Submissions Report

Punchbowl, Affordable Housing, State Significant Development

150 The Boulevard and 34 Dudley Street, Punchbowl

SSD-83256463

3 Ground Floor
1:50

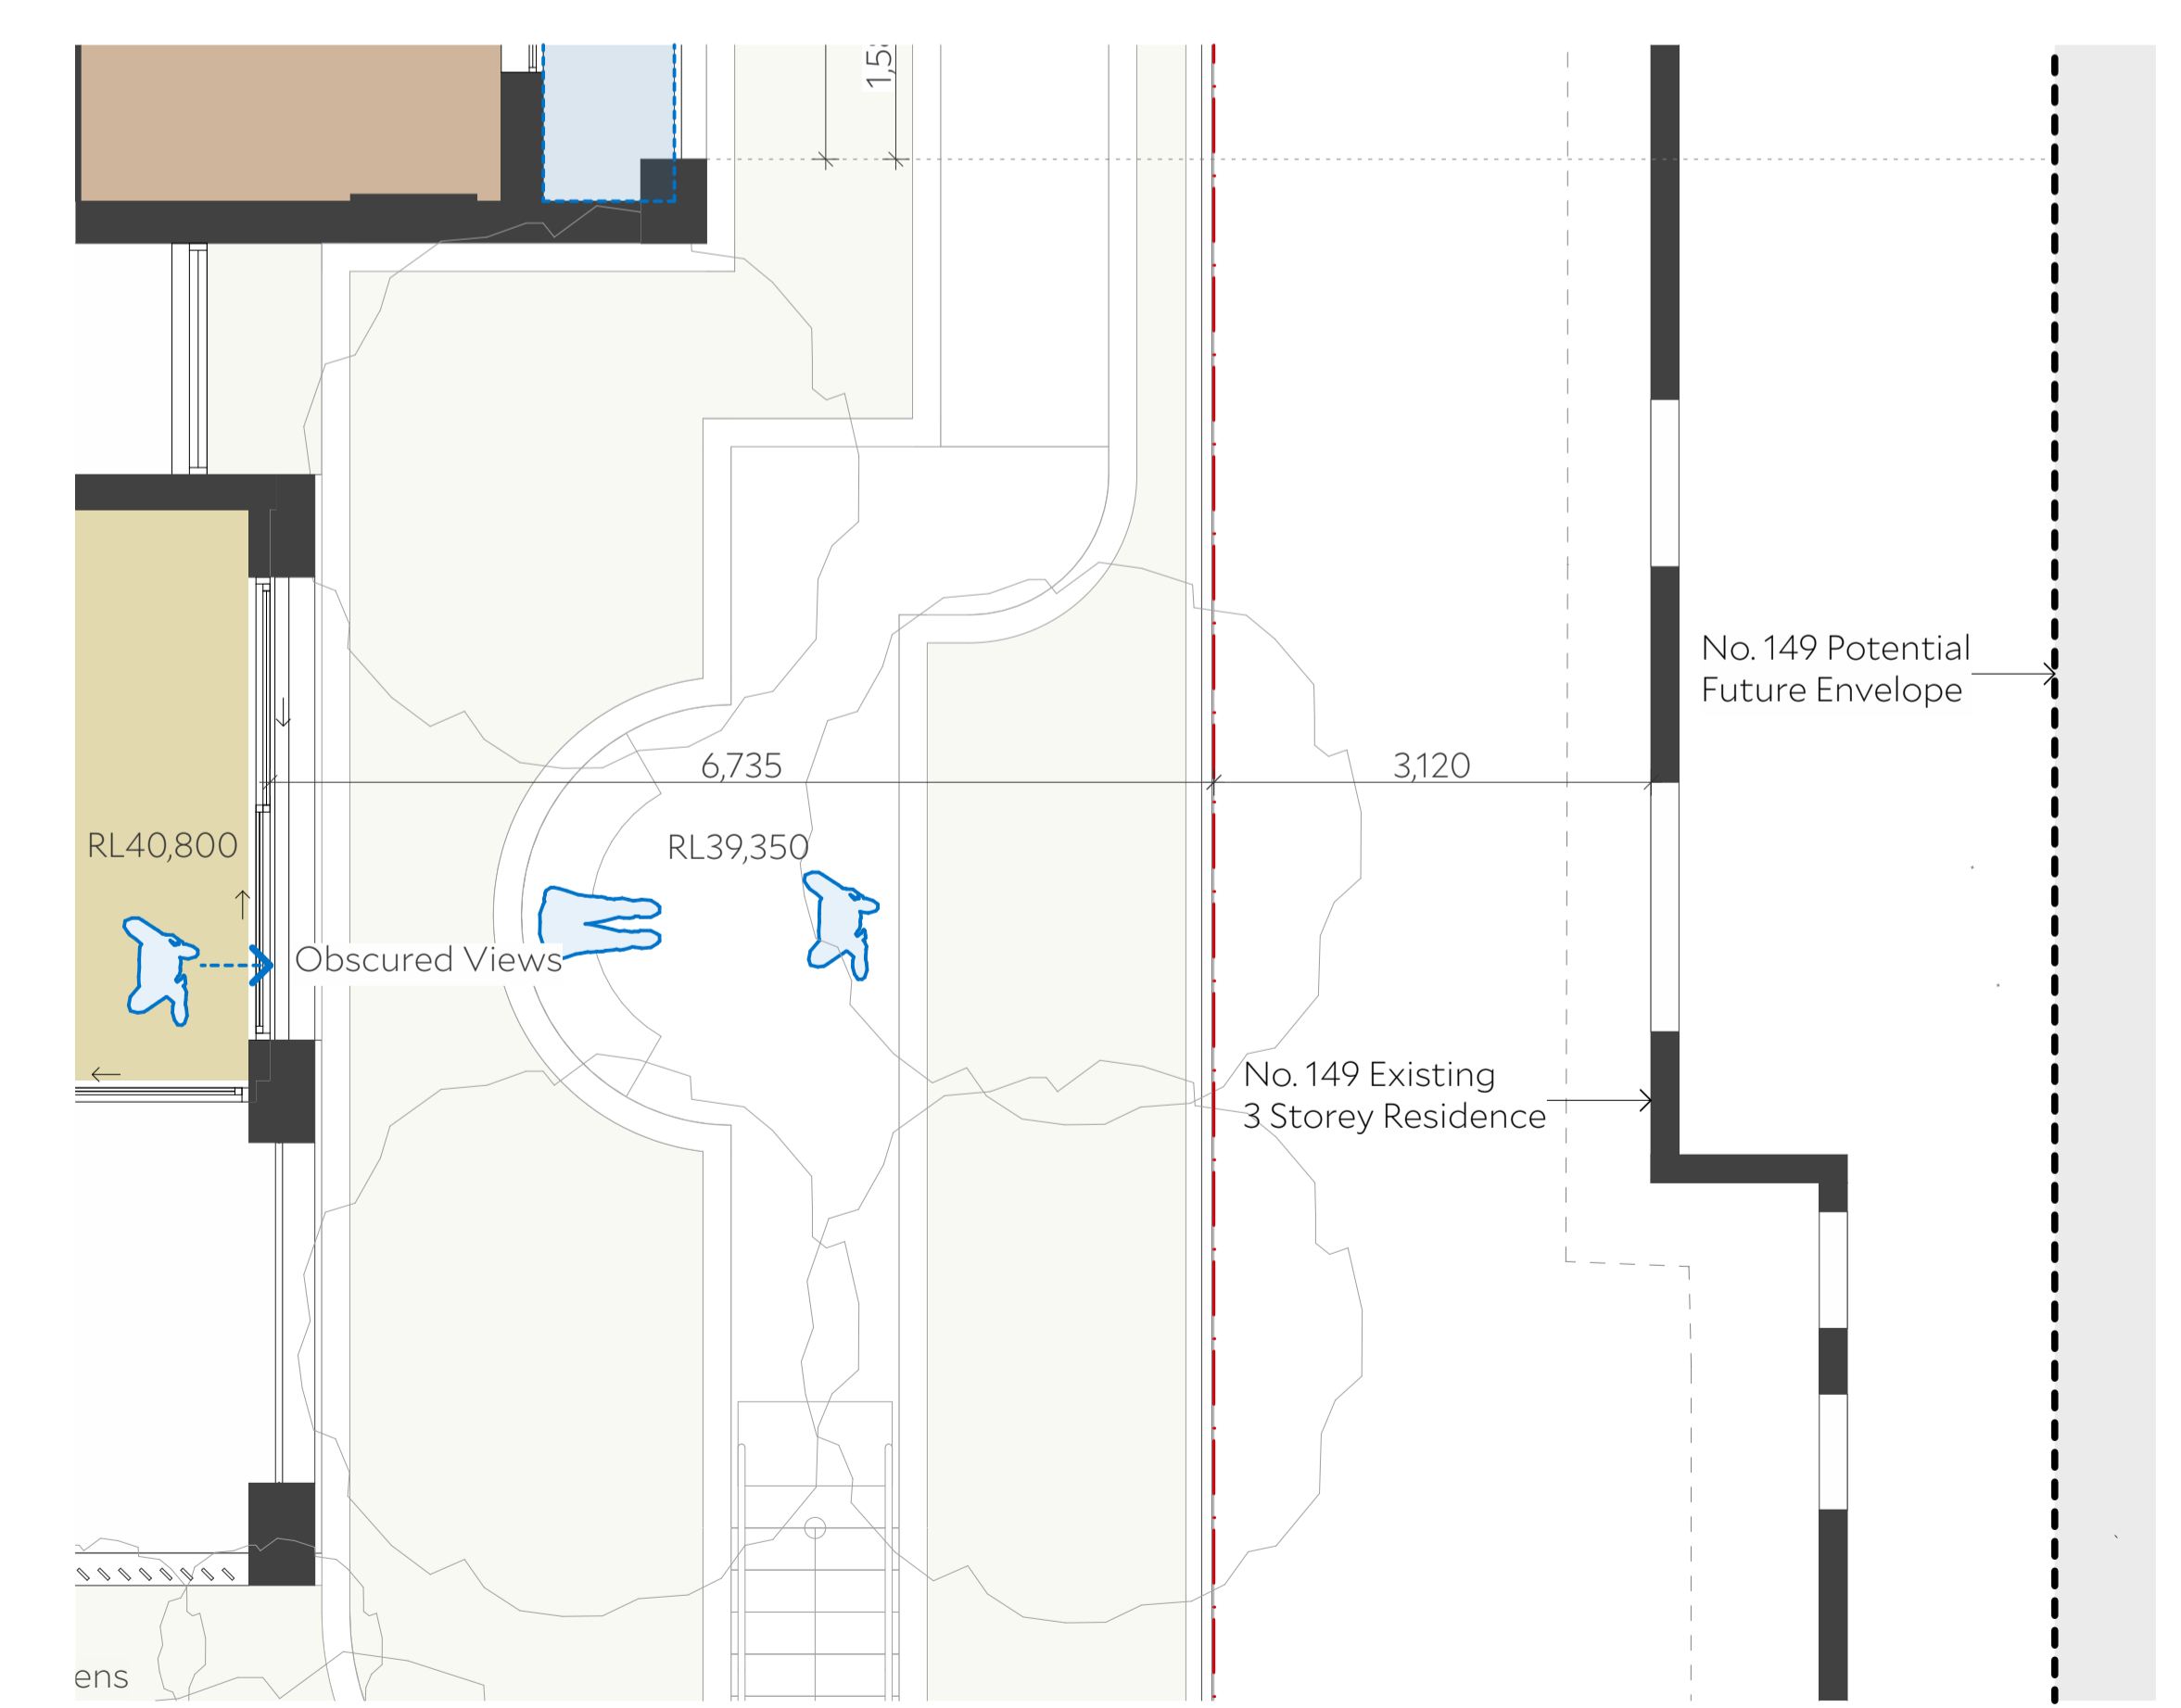
No.	Issue raised	Response
	across all levels to improve solar access or demonstrate why this cannot be achieved.	
2.5	Provide details to demonstrate how adequate privacy is achieved to ground floor courtyards of apartments fronting communal open space (apartments A.G06 and A.G07).	The proposed landscaped pathways located in front of the ground floor apartments fronting the communal open space (apartments A.G06 and A.G07) have been repositioned to move the pathways further from the apartments to improve privacy. Further, as shown on the updated Architectural Plans at Appendix B, privacy screens have been incorporated on the balconies of these ground floor apartments to ensure a high level of privacy is achieved.

1 Visual Privacy - A.x07 to No.149 The Boulevard
1:50

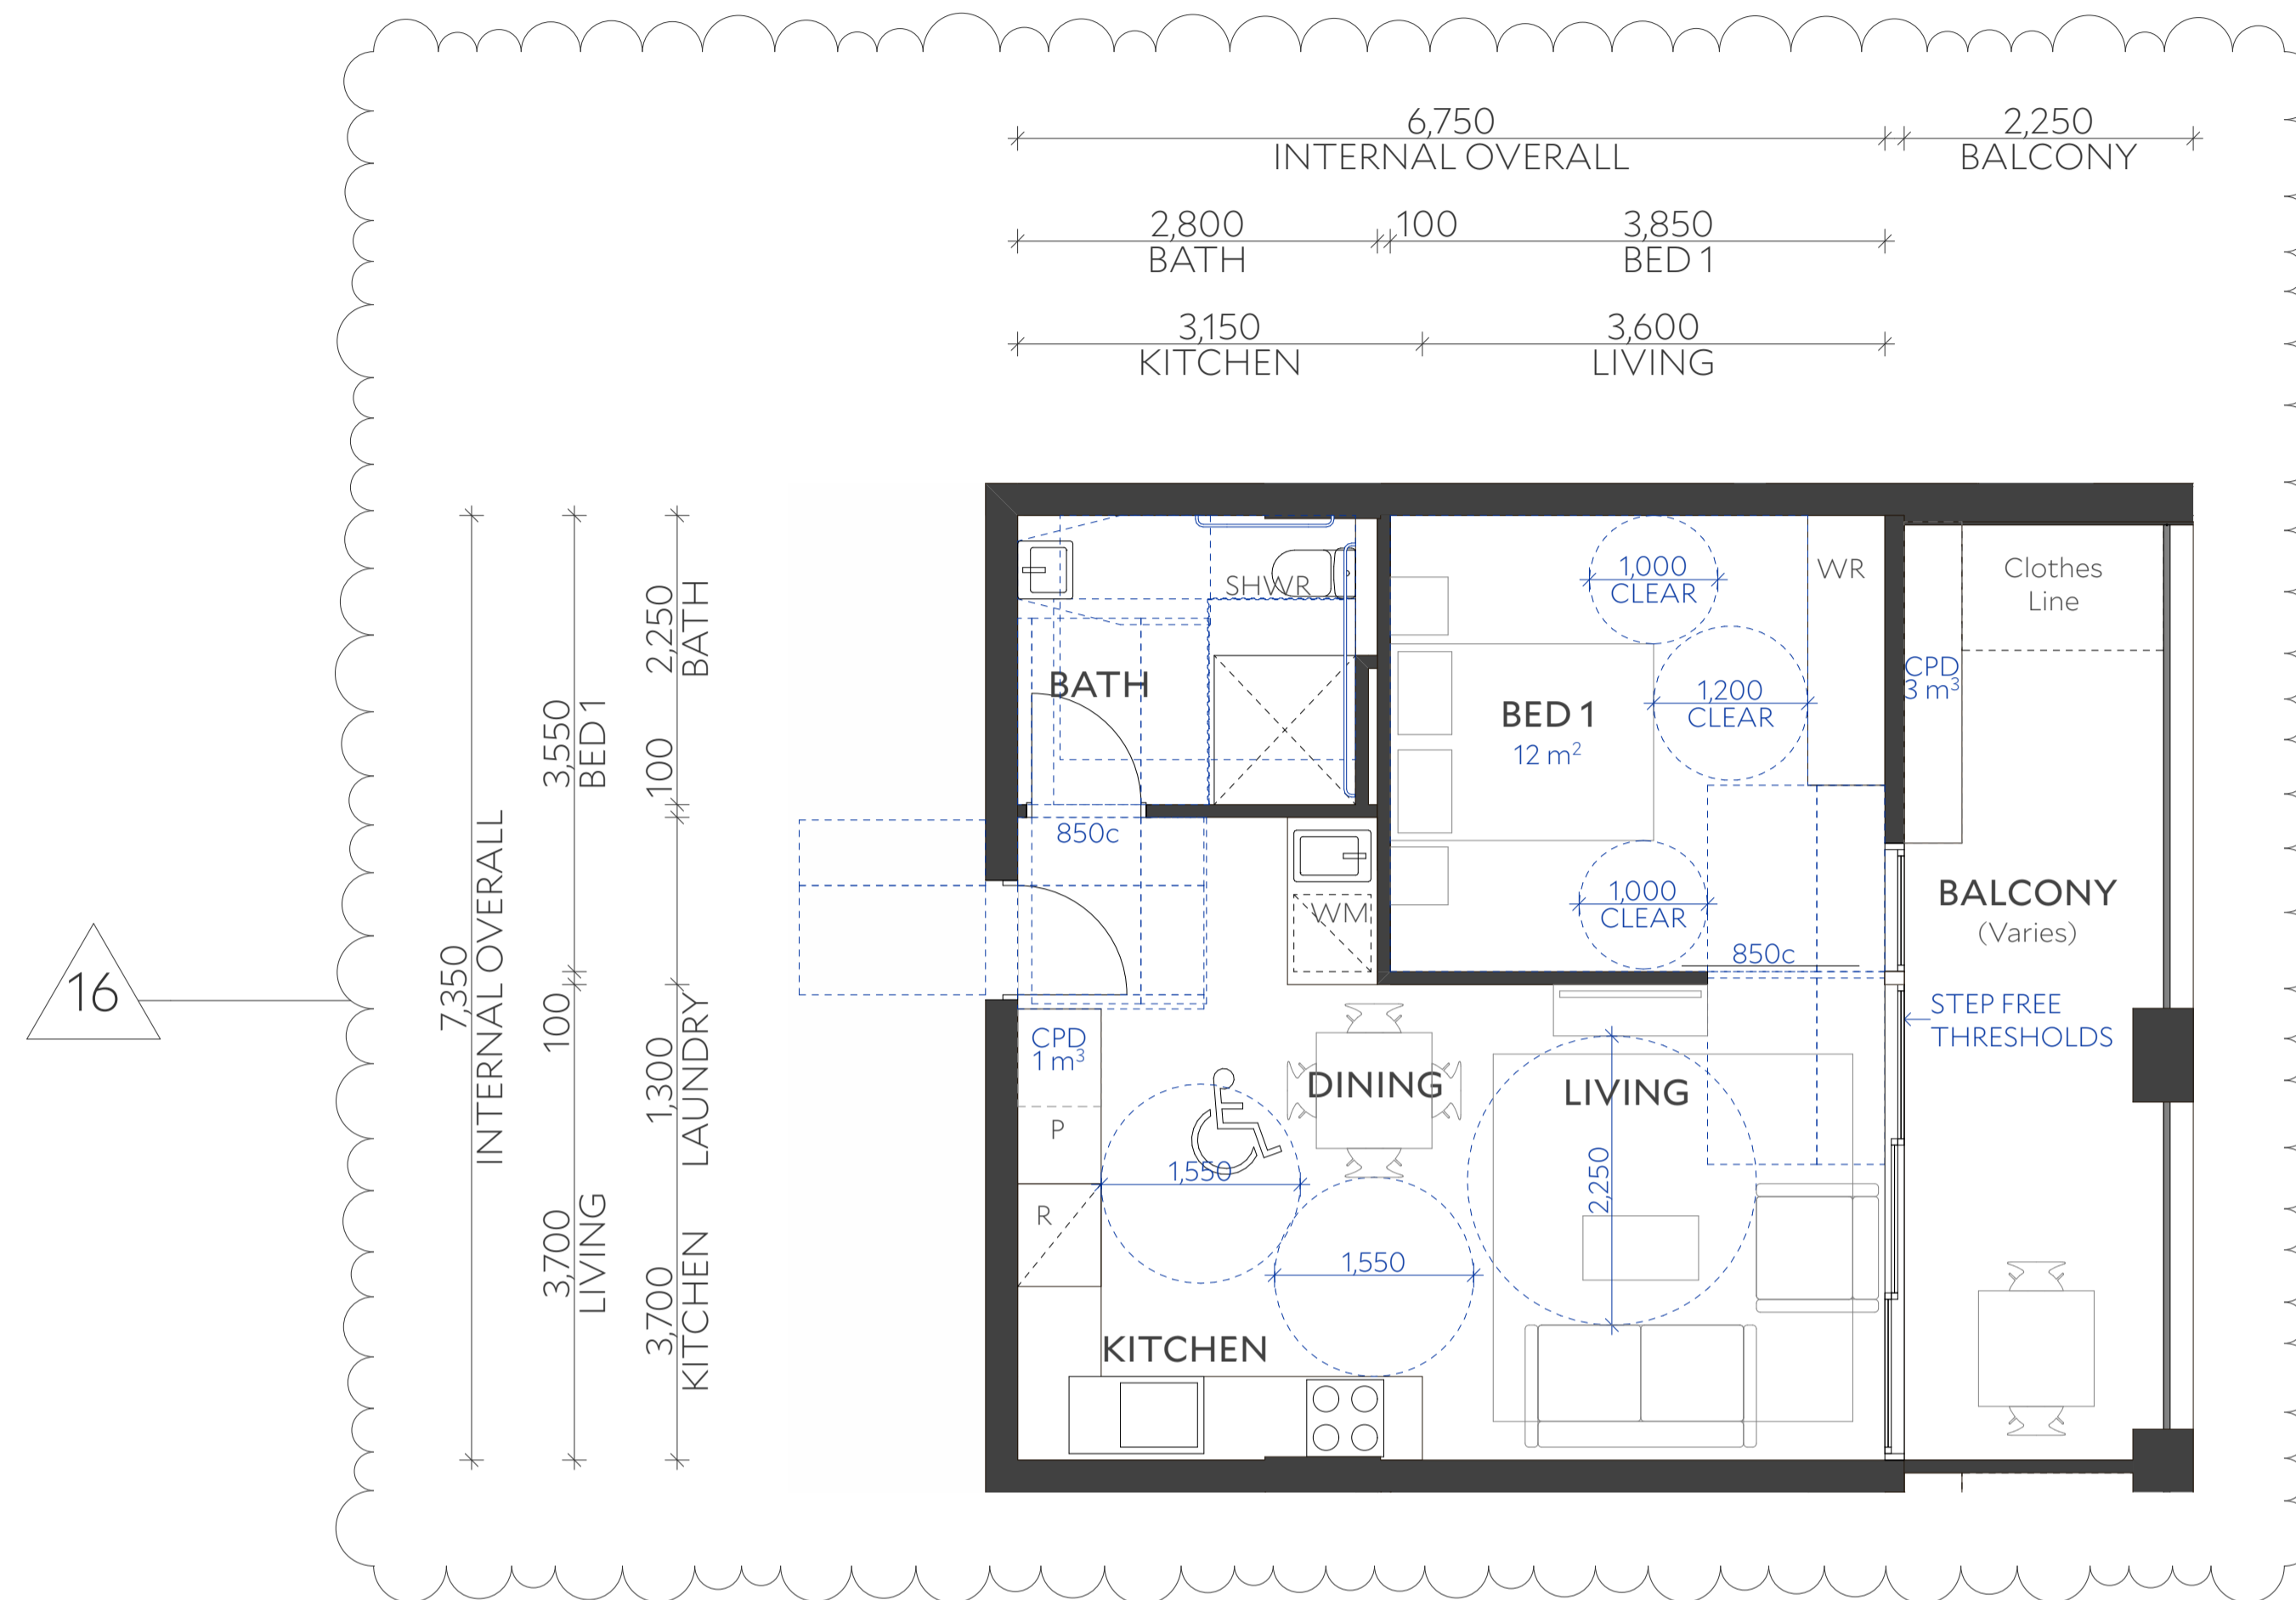
No.	Issue raised	Response
2. Residential amenity		
2.1	The proposed building separation to the southern and eastern boundaries is inconsistent with section 3F of the Apartment Design Guide (ADG). Provide updated Architectural Plans to include necessary privacy treatments to the following areas of the development: – Building A: east elevation balconies of apartments A.407, A.507, A.607, and A.707 – Building B: south elevation habitable room windows, above 4 storeys	The proposal has been subject to a design excellence process via the State Design Review Panel (SDRP). The proposal was subject to two design reviews, with the recommendations and advice of the Government Architect NSW (GANSW) being addressed in the proposal. Importantly, the reduced setback to the east has been considered through the SDRP design review process with the GANSW confirming, this element is to be retained to achieve design excellence. The east-facing balcony projections for apartments A.407, A.507, A.607 and A.707 directly respond to the advice received at the first SDRP held 20 June 2025. The advice dated 27 June 2025 from GANSW recommended a more urban frontage by aligning the floor plan with The Boulevarde and extending the balcony expression to define the street. The advice recommended that a more urban approach to The Boulevarde was explored by cranking the floor plan to run parallel to the street and extending the architectural expression of the balconies to define the street. This recommendation was a response to the project's generous setback at the corner of The Boulevarde and Dudley Street for the retention of the existing spotted gum. The eastern balcony projections are intentionally non-trafficable due to their narrow width and function solely as façade articulation, providing expression and depth while preventing overlooking toward 149 The Boulevarde. Following the second SDRP in August 2025, GANSW confirmed the elements to be retained to achieve design excellence included the general form and massing strategy for the building, as appropriate to the future urban character and increased scale and density of the TOD rezoning area, including: – articulation to align with The Boulevarde and respond to the street corner and it's spotted gum – maximising the street wall at The Boulevarde for this relatively limited frontage via a reduced setback at the eastern boundary. The proposal is consistent with the design advice provided by GANSW, and the clear advice that the reduced setback to the east is an element to be retained to achieve design excellence for the proposal. The glazing to habitable windows on the south elevation (above four storeys) has been revised to provide translucent glass. This will provide enhanced privacy and ensures the proposal achieves compliance with the visual privacy objectives in Section 3F of the ADG. Refer to the updated Architectural Plans at Appendix B.

5.4	Apartment Design Guide (ADG) The proposal does not meet the required building separation control in 3F in the ADG, specifically the setback from the eastern boundary and there is no environmental planning reason to support this departure. <u>Recommendation:</u> That the following be provided: – Amended plans be provided that comply with 3F; or – Environmental planning reasons be provided to justify the non-compliance.	The proposal was subject to two design reviews by the State Design Review Panel (SDRP) to ensure the proposal achieves a high level of design excellence. The east-facing balcony projections for apartments A.407, A.507, A.607 and A.707 directly respond to the SDRP 1 advice (dated 20 June 2025), which recommended a more urban frontage by aligning the floor plan with The Boulevard and extending the balcony expression to define the street. This recommendation was a response to the proposal's generous setback at the corner of The Boulevard and Dudley Street for the retention of the existing spotted gum. The eastern balcony projections are intentionally non-trafficable due to their narrow width and function solely as façade articulation, providing expression and depth while preventing overlooking toward 149 The Boulevard.
